September 6, 2024

Re: **Responses to Comments** –
Harborview Heights – Technical Review 1
SP23-007

City of Marysville Community Development – Planning Division

DATE: 5-Aug-24
JOB NO: 2023 052
DRAWN: SH
CHECKED: EN
REVISION:
SITE/UTILITY PLAN
SHEET: SP-01

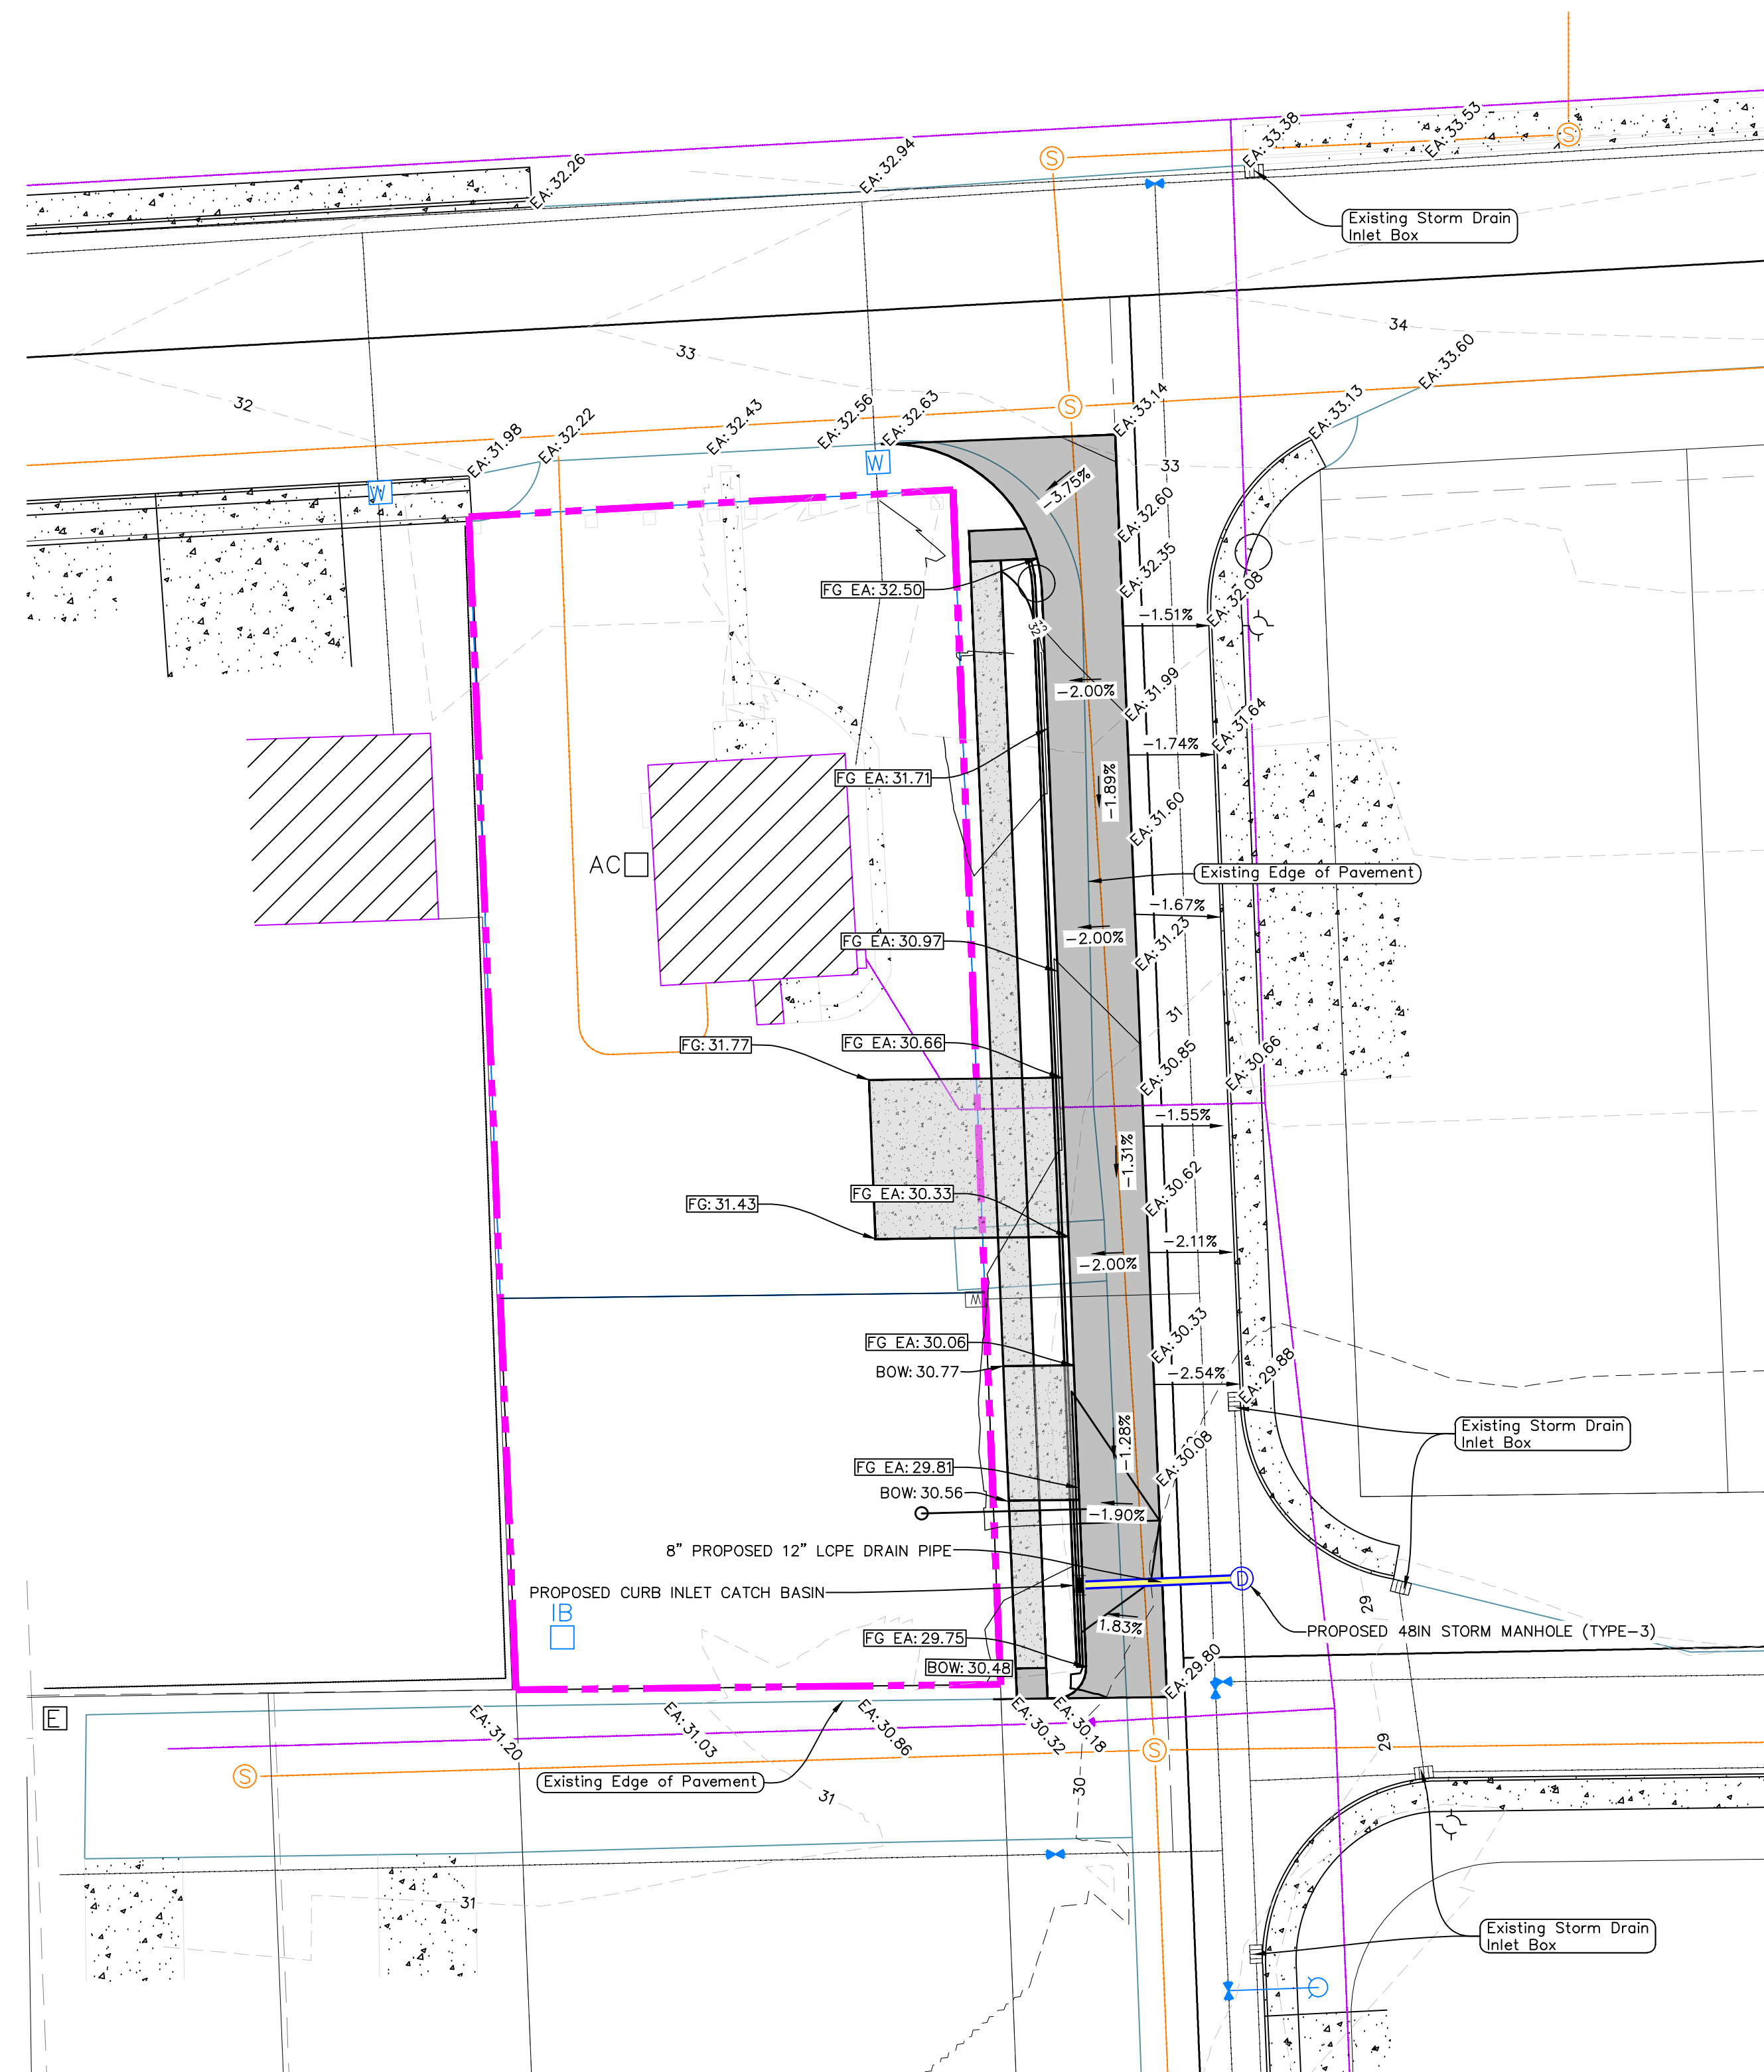
- 8. Amend sheet SP-01 to depict existing side sewer service to the existing house on lot 1.

[The existing side sewer service to the house on lot 1 is shown on the site plan and other drawings.]

LS-01

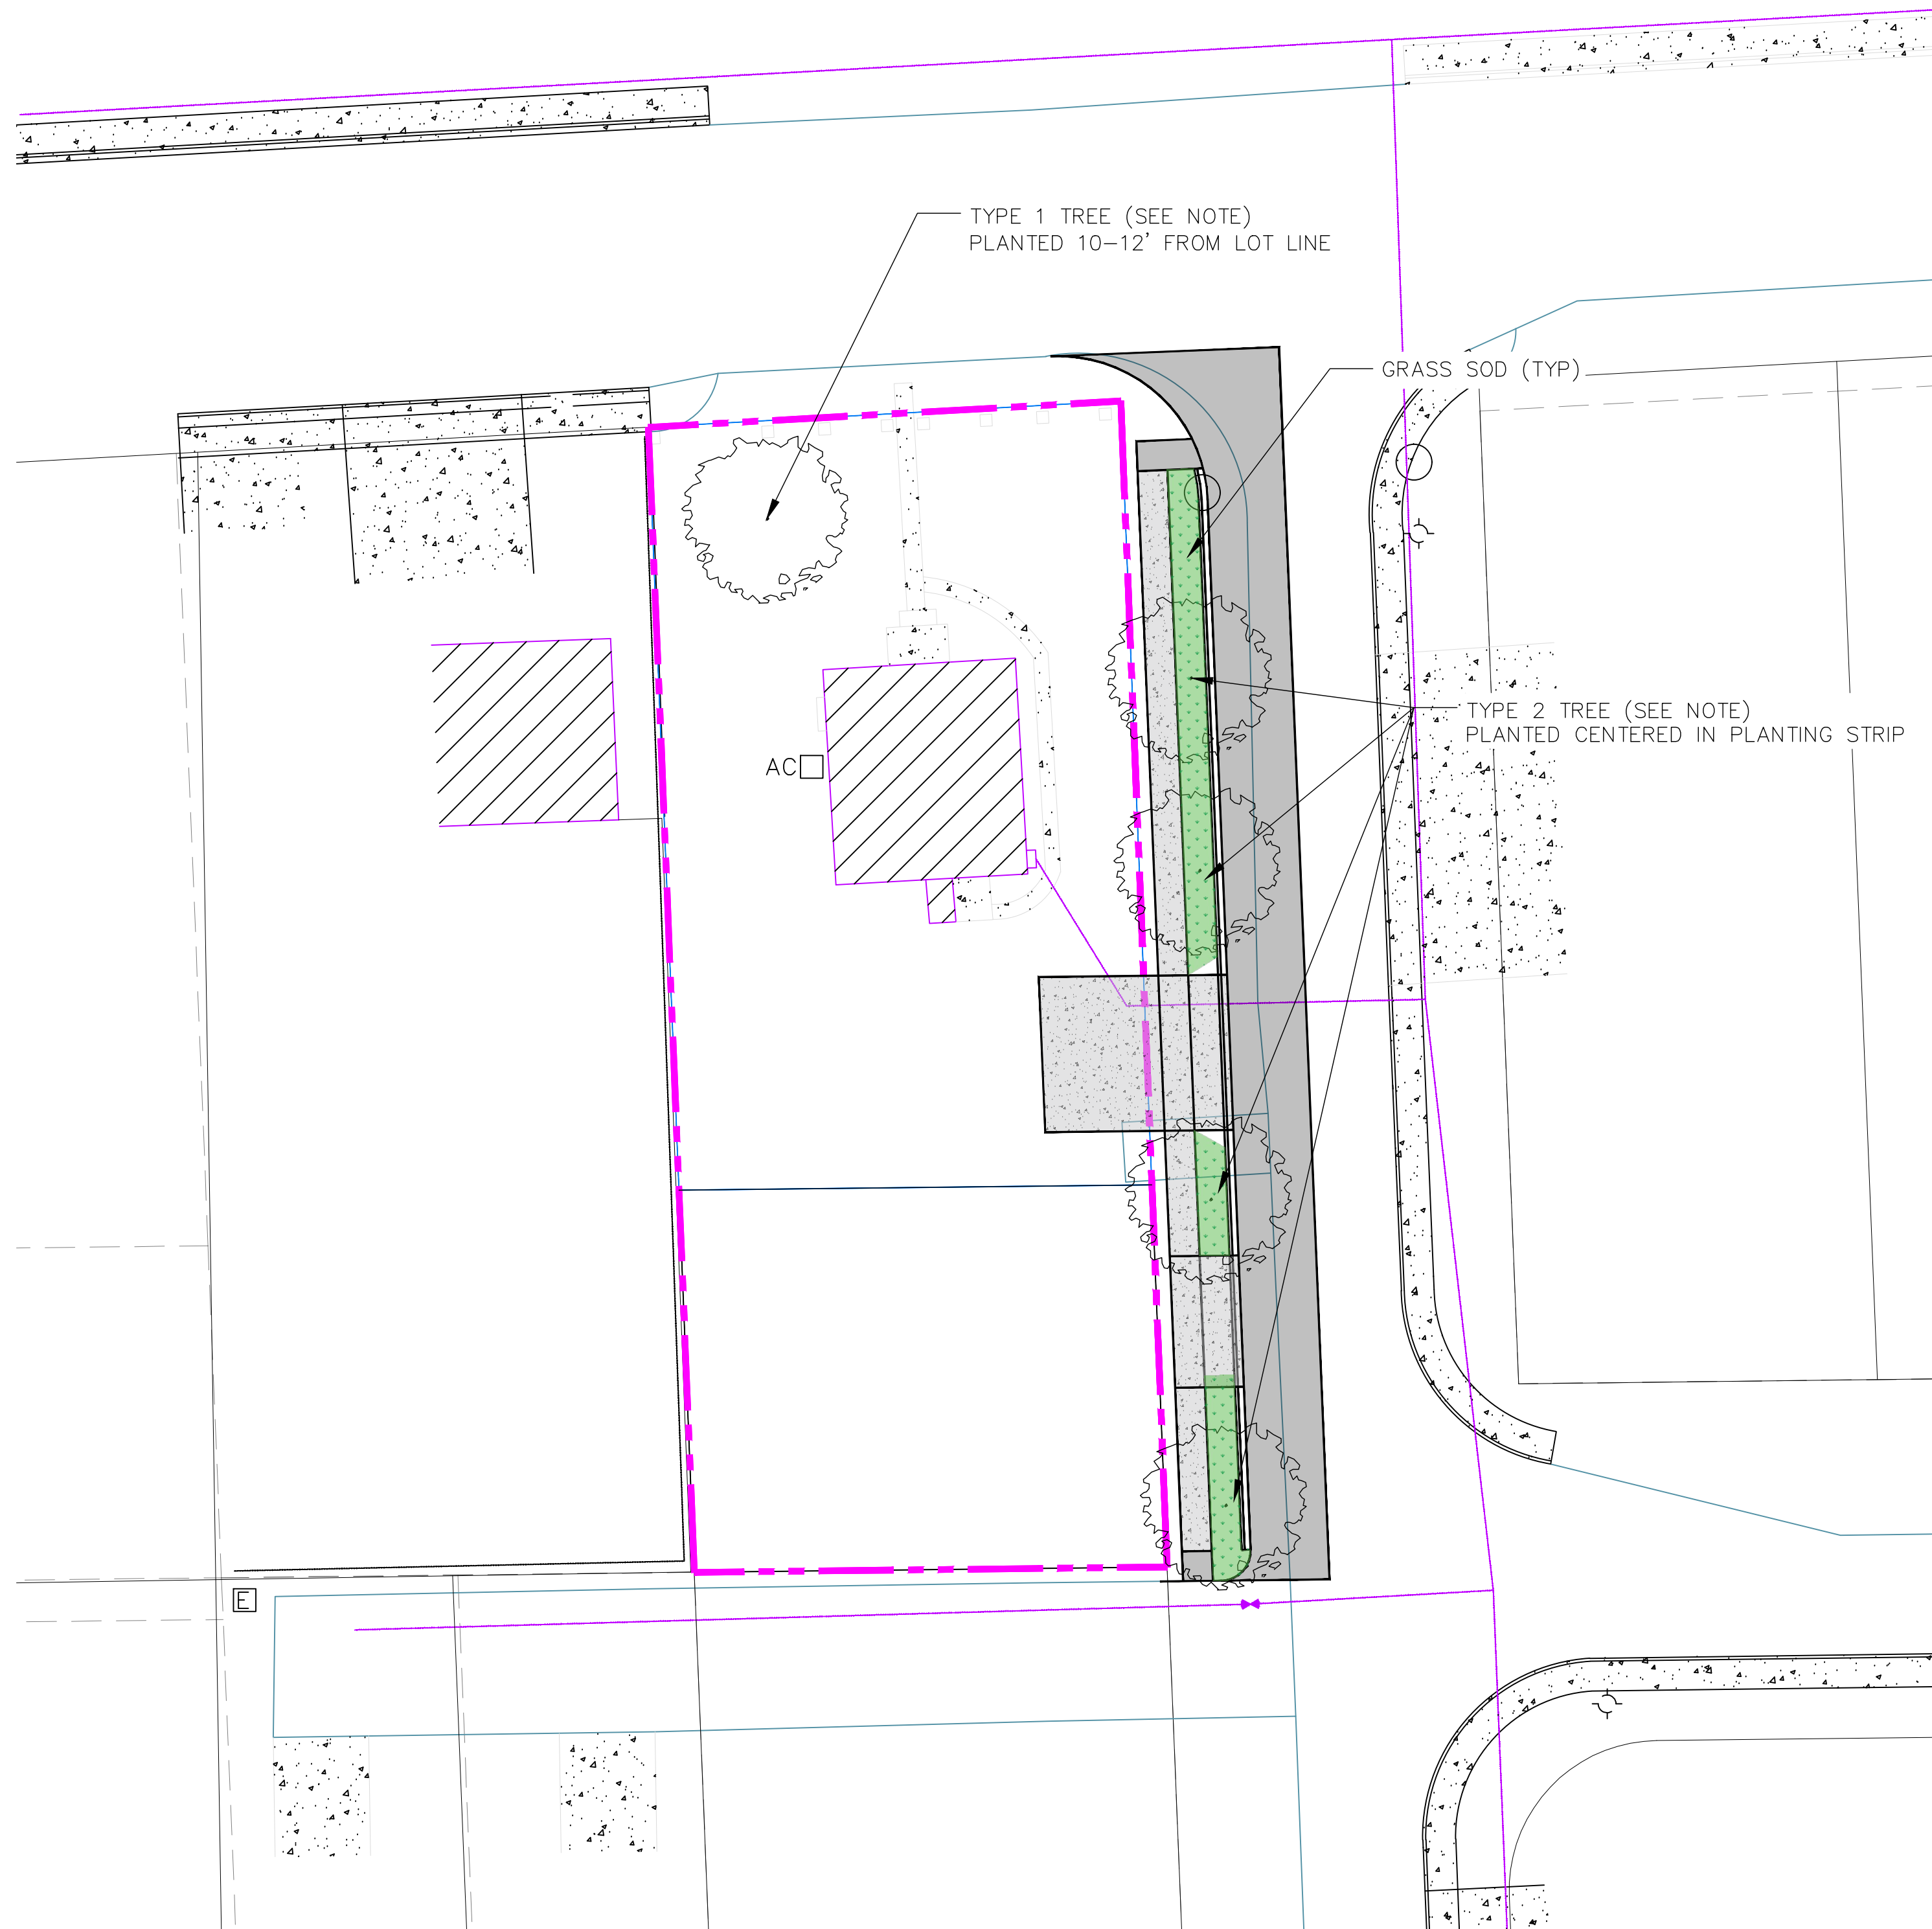
- 6. The applicant shall be required to submit a preliminary landscaping plan that includes the following:
 - a. Street trees on 61st St NE and 52nd Ave NE shall be installed 1 per 30ft of frontage. Along 61st NE street trees shall be planted a minimum of 5ft behind the ROW. Street trees along 52nd Ave NE shall be planted between the curb and the walking path of the sidewalk.
 - b. Provide a detailed planting plan of the proposed bioswales along 52nd Ave NE.
 - c. Street trees shall meet the most recent ANSI standards for a one-and-one-halfinch caliper tree at the time of planting.
 - d. Provide a detail of root barrier on the preliminary landscape plans as outlined in the Engineering Design and Development Standards, Section 3-504, Street Trees and Landscaping, and Standard Plan 3-504-001.

[A landscaping plan is included with the Civil Plans]
